M3 Junction 9 Improvement Scheme

Scheme Number: TR010055

7.12.2 Statement of Common Ground with South Downs National Park Authority (Rev 1)

16 November 2023

Figure 7.7.1: Typical arrangement of gantry floodlighting

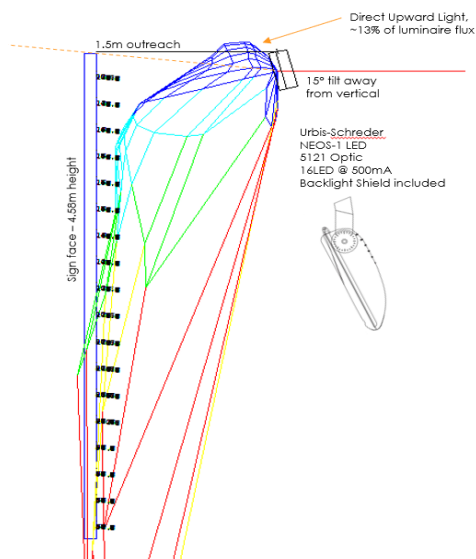
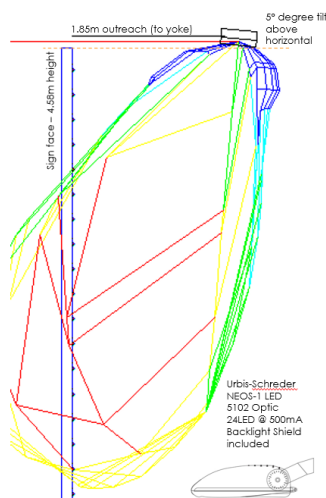
5.3	Assessment methodology Lighting, including Dark Night Skies	Chapter 7 (Landscape and Visual) of the Environmental Statement (ES) (6.1, Rev 1), Appendix 7.7 (Technical Note Lighting Assessment of Gantry Signage) of the ES (6.3, APP-103)	<p>15 June 2023</p> <p>As set out in Paragraph 6.23 of our Local Impact Report (REP2-071). The SDNPA welcomes the general approach by the applicant to avoid and minimise the impacts of lighting and the statement, including the commitments in the First Iteration Environmental Management Plan (application document APP-156), that lighting would be designed in consultation with the SDNPA and in accordance with the SDNPA's Dark Skies Technical Advice Note Version 2 (May 2021), which accompanies Policy SD8.</p> <p>However, we do have concerns over the assessment – due to the issues with the visualisations, set out above and this in turn could have an impact on the lighting assessment and mitigation measures.</p>	<p>17 July 2023</p> <p>Following discussion at Issue Specific Hearing 1 (ISH1), National Highways updated Figure 7.14 of Chapter 7 (Landscape and Visual – Figures) (Part 3 of 3) (6.2, Rev 1).</p>	Not agreed	25 October 2023

**FIGURE 9A**  
*Environmental Masterplan & LVIA Viewpoints*

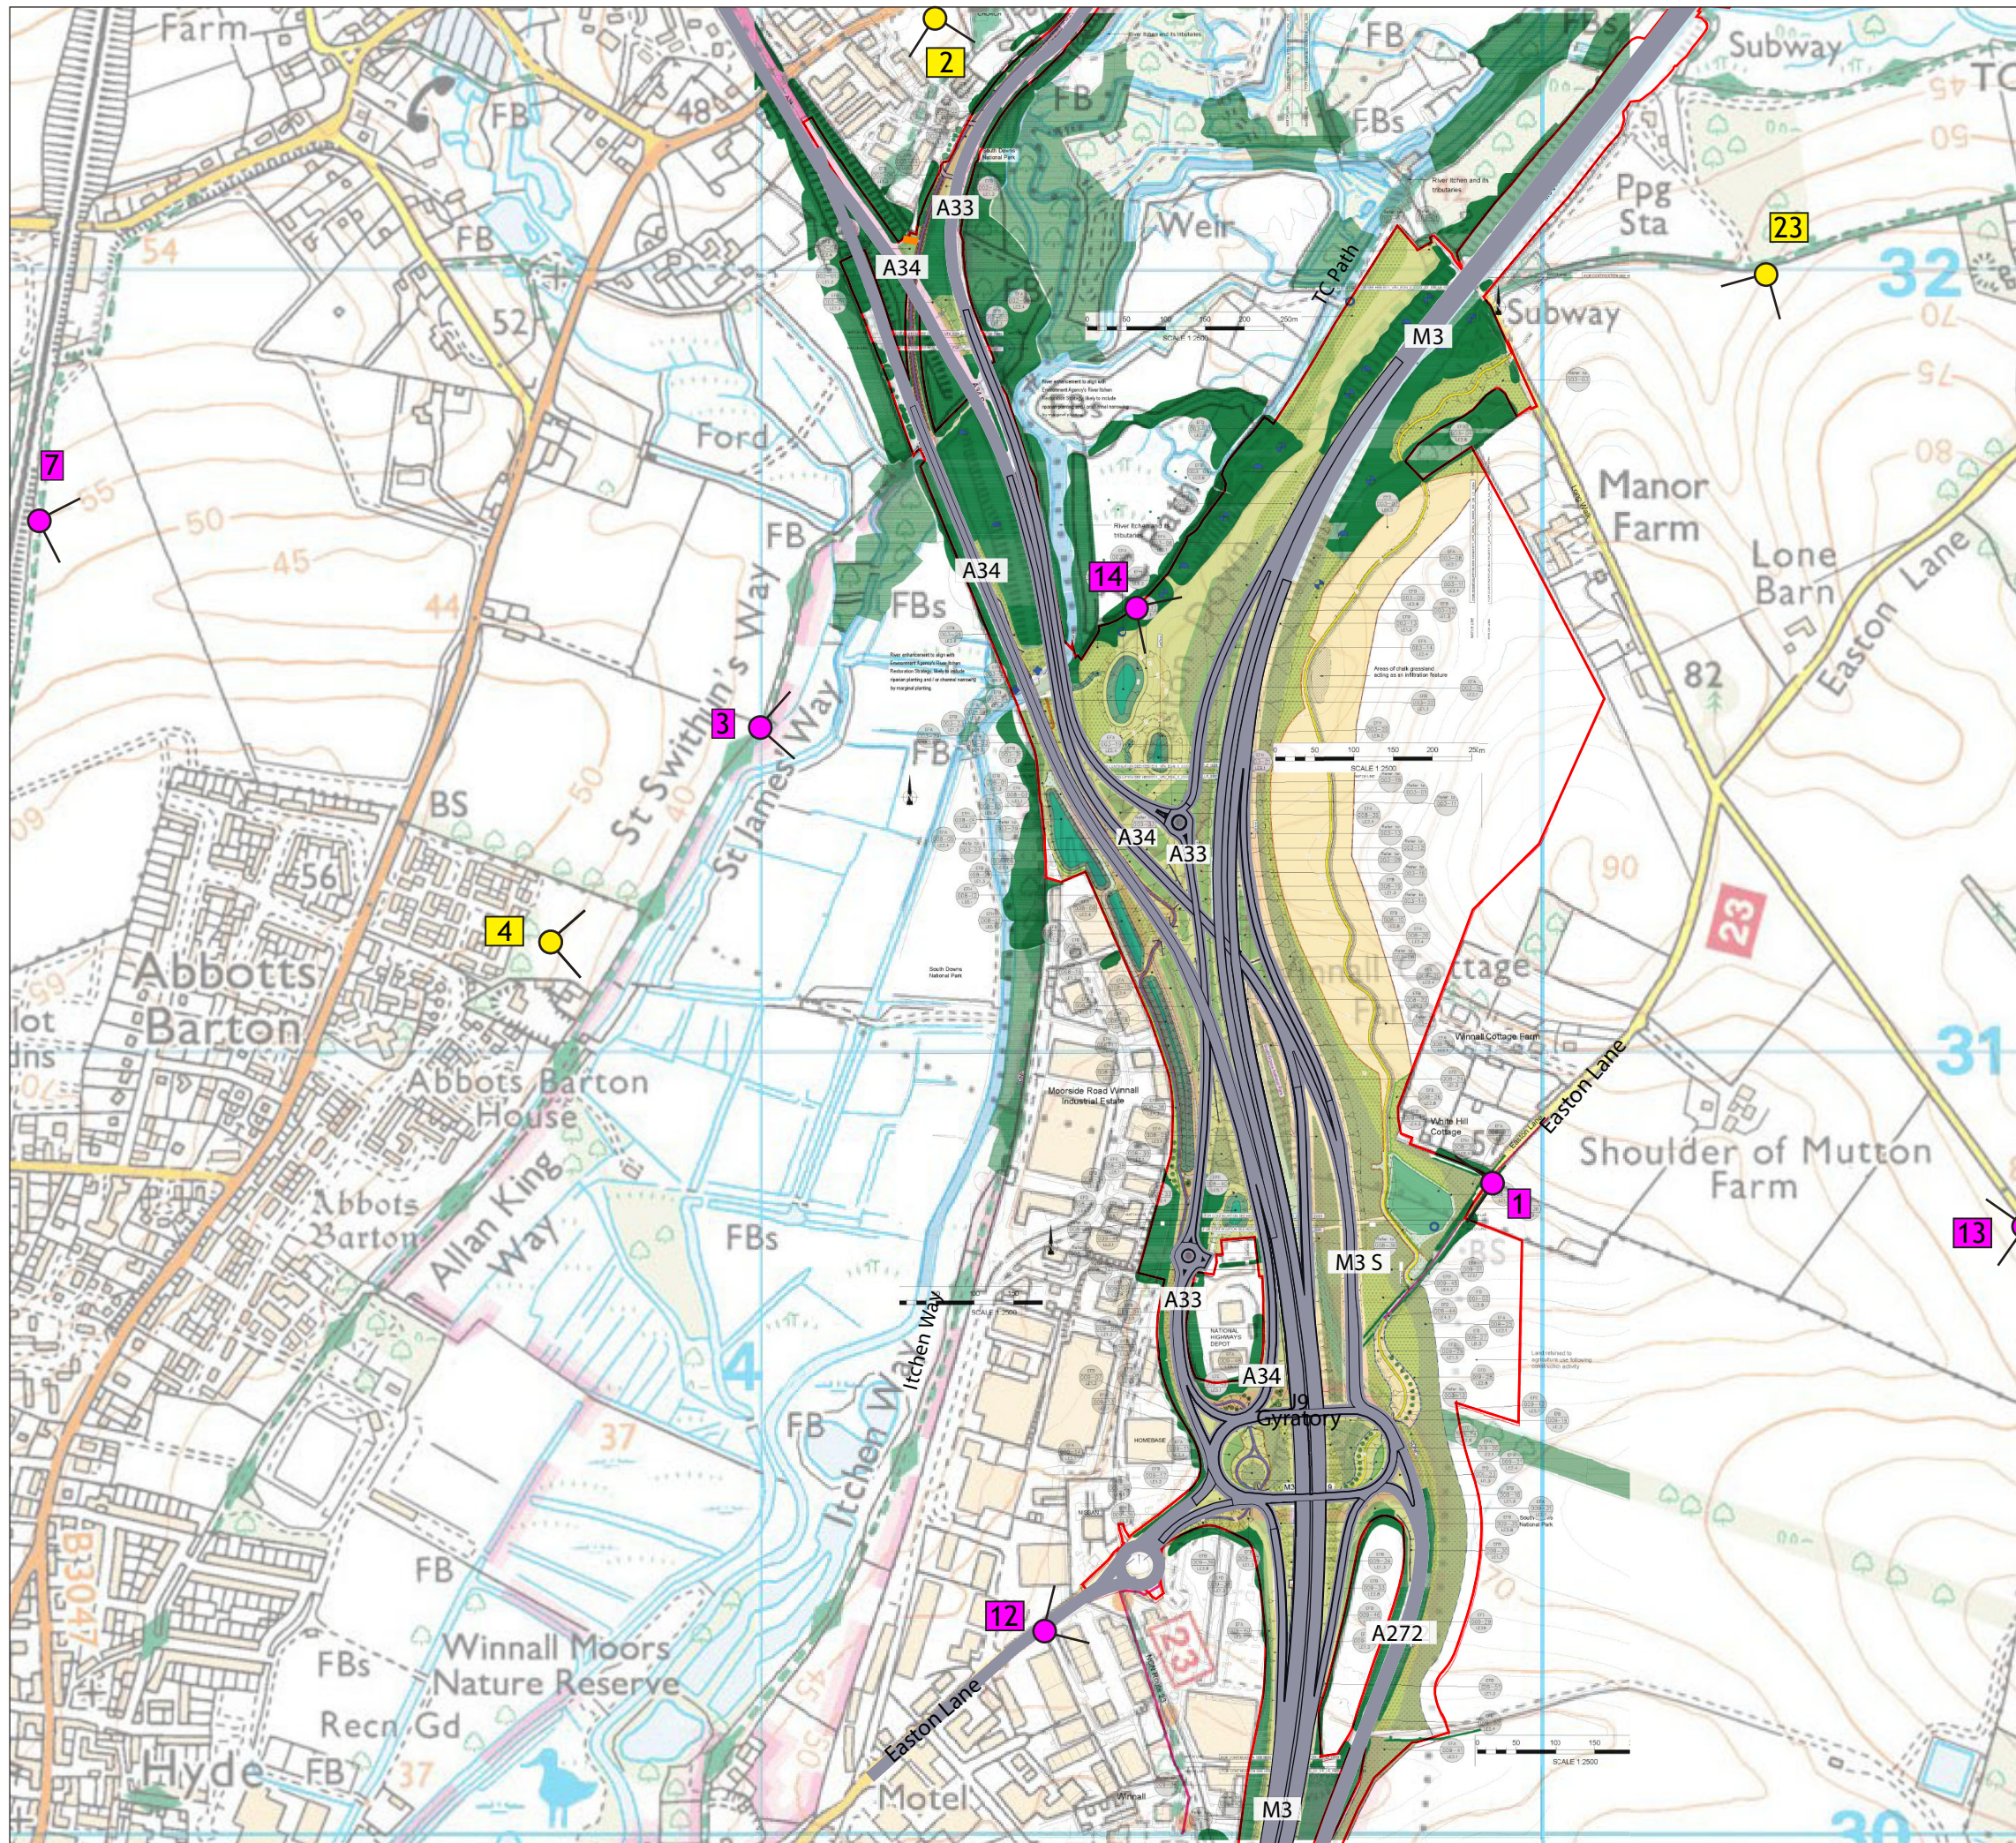
2.4	<p>Application Boundary</p> <p>Chalk grassland and farmland interface</p> <p>Cart and Horses junction</p>	Figure 2.3 (Environmental Masterplan) in Chapter 2 (The Scheme and its Surroundings – Figures (Part 2 of 4)) of the ES (6.2, Rev 1), South Downs National	<p>15 June 2023</p> <p>See paragraphs 6.14(e) and 6.32 of our Local Impact Report (REP2-071) and 3.1.17(e) and 3.2.1(a) of our Written Representation (REP2-075), which highlight two issues:</p> <ul style="list-style-type: none"> Chalk grassland and farmland interface The exclusion of the Cart and Horses Junction 	<p>Assurance of mitigation and compensation would be secured through the DCO with reference to Figure 2.3 (Environmental Masterplan) in Chapter 2 (The Scheme and its Surroundings – Figures (Part 2 of 4)) of the ES (6.2, Rev 1).</p> <p>The Cart and Horses junction is outside the Application Boundary and no work is proposed to the junction as part of the Scheme.</p>	Not agreed	21 July 2023

Reference	Issue	Document References (if relevant)	South Downs National Park Authority's Position	National Highways' Position	Status	Date
5.9		2.3 (Environmental Masterplan) of Chapter 2 (The Scheme and its Surroundings – Figures (Part 2 of 4)) of the ES (6.2, Rev 1) , the Design and Access Statement (7.9, APP-162)	24 December 2021 The OLEMP references habitat restoration or replanting having to reflect extant Landscape Character, however, the South Downs National Park Authority requests reference to local assessments and typologies, and further commitment to the special qualities of the National Park.	23 February 2022 The Design and Access Statement (7.9, APP-162) explores these points further, however further detail has been provided within the OLEMP referencing to the landscape character and special qualities of the South Downs National Park.	Not agreed	25 October 2023
